CONSTRUCTION DOCUMENTS

FALCON MARKETPLACE

75% SUBMITTAL 12-20-18

COVER SHEET

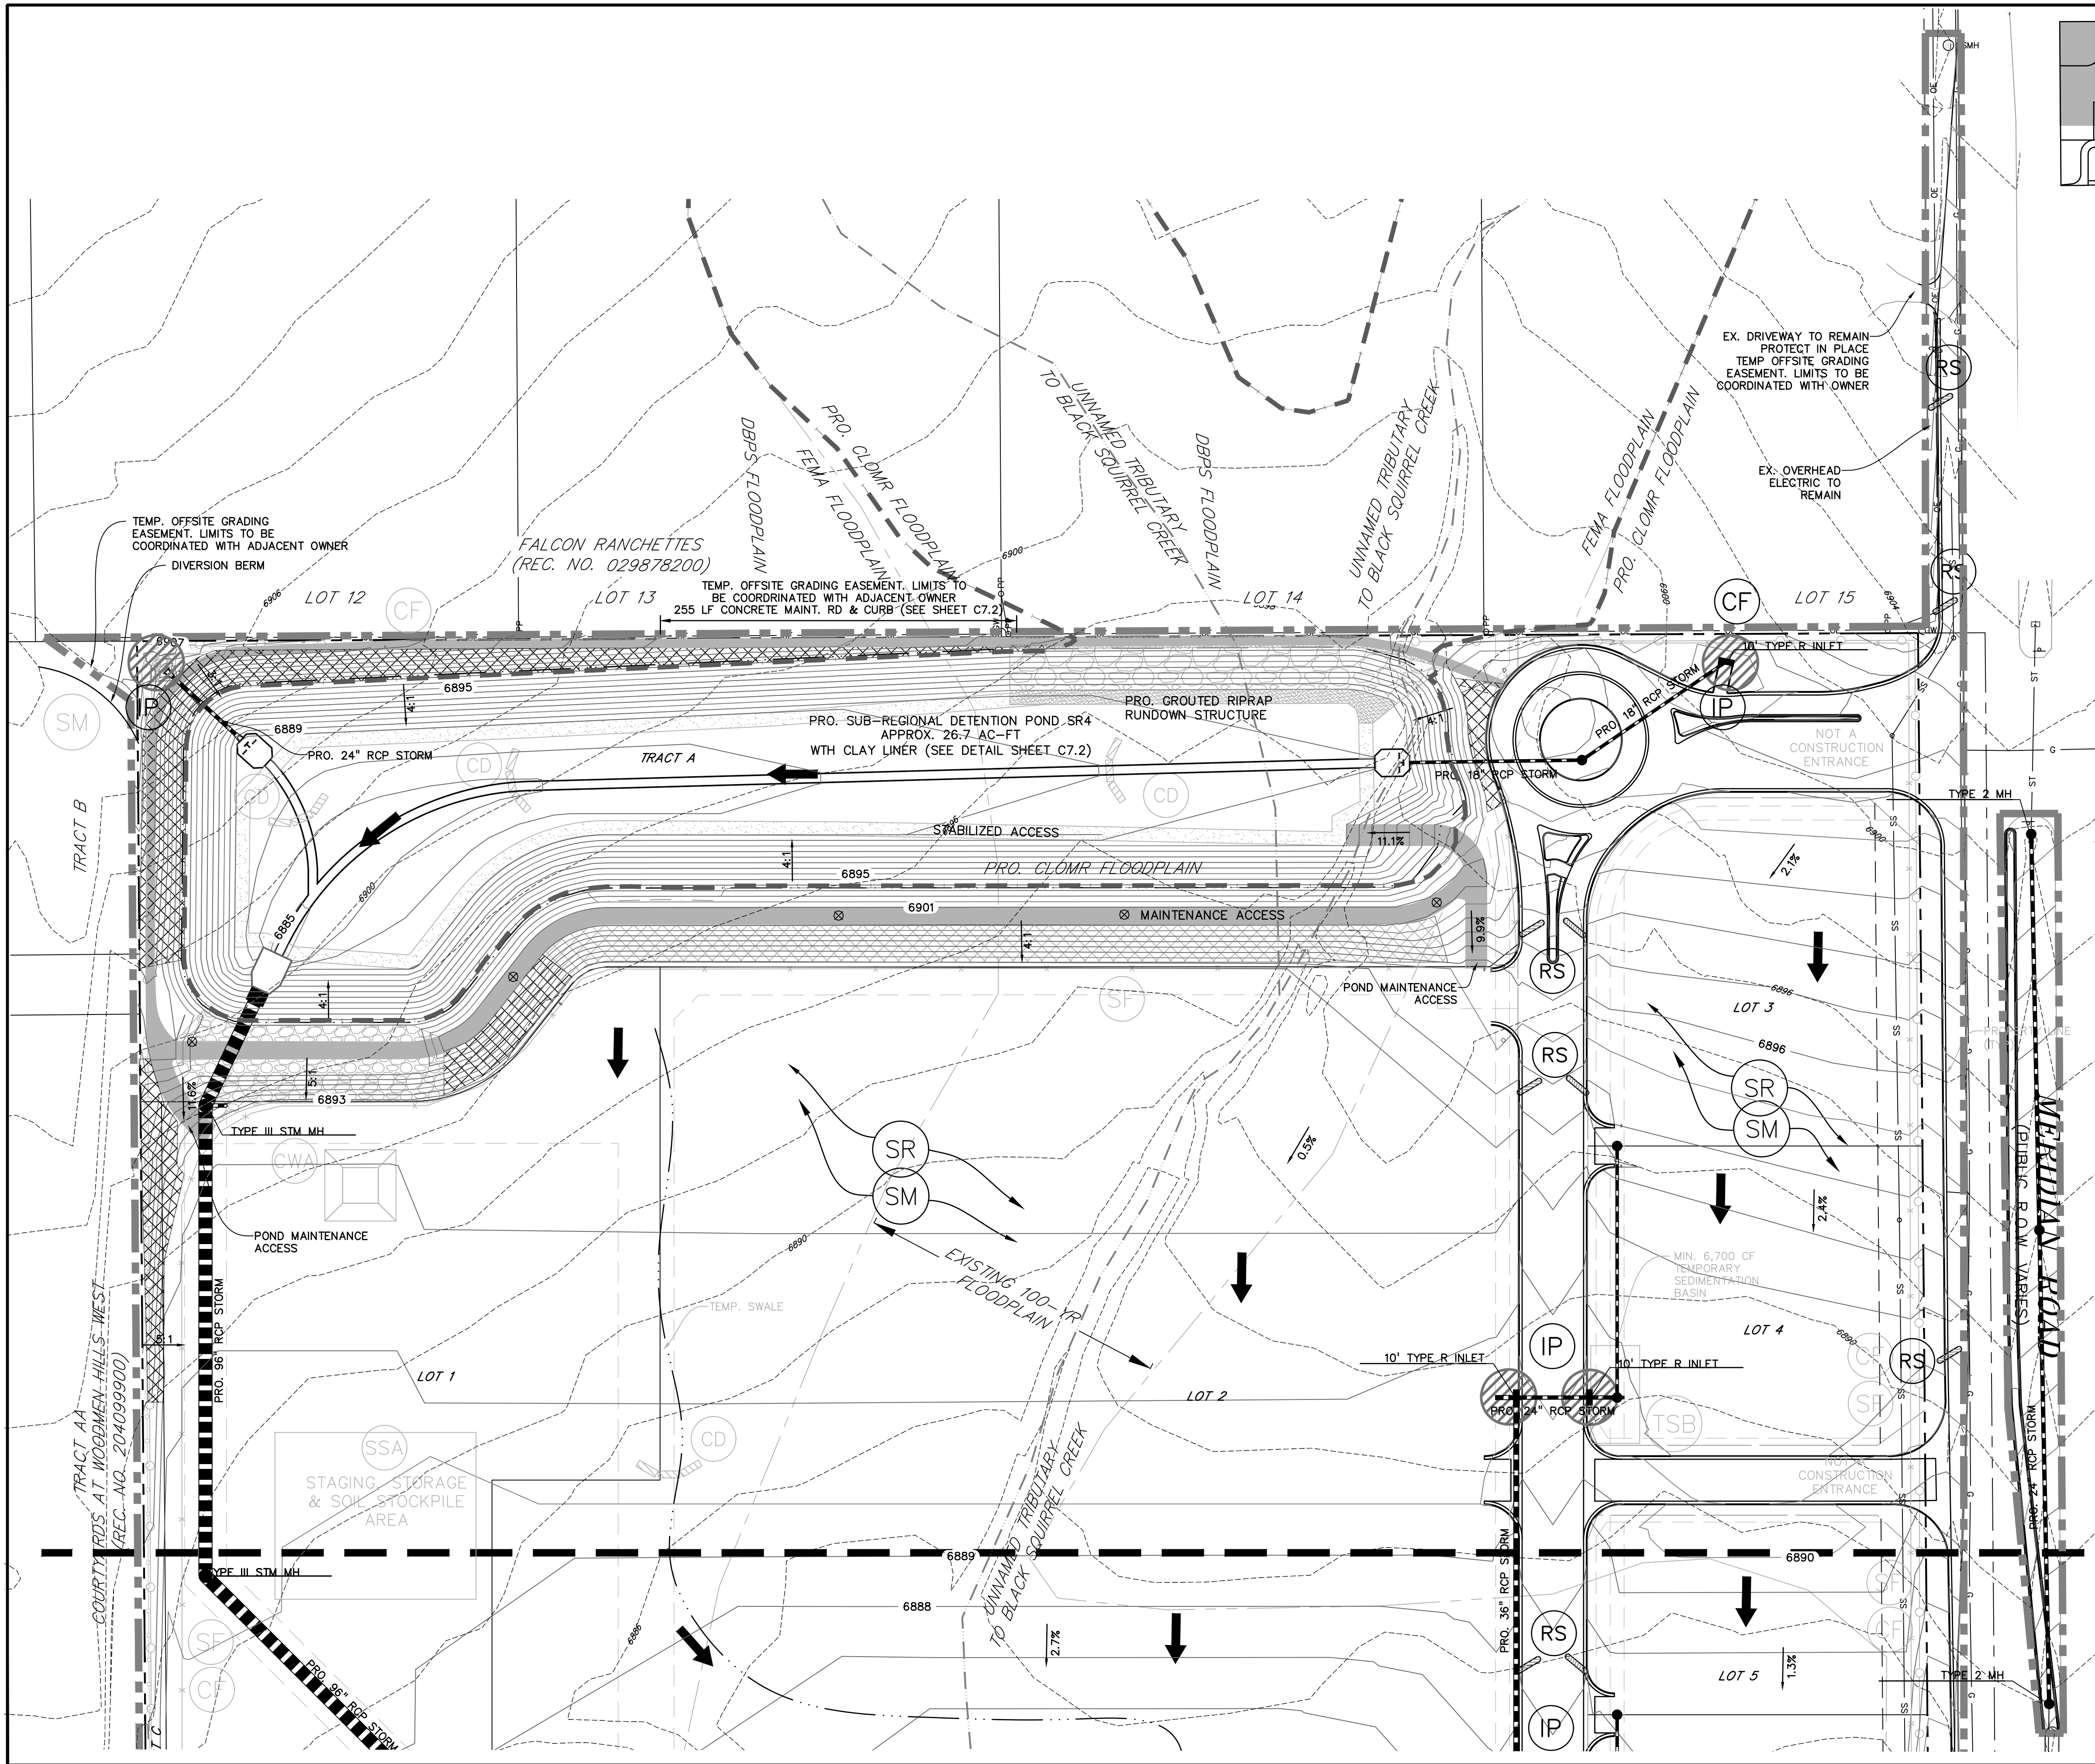
Round a bout
comments
forthcoming and will
be provided by
Engineer when he
uploads his additional
comments

See comment letter.

Provide Eastonville Road Widening Plans
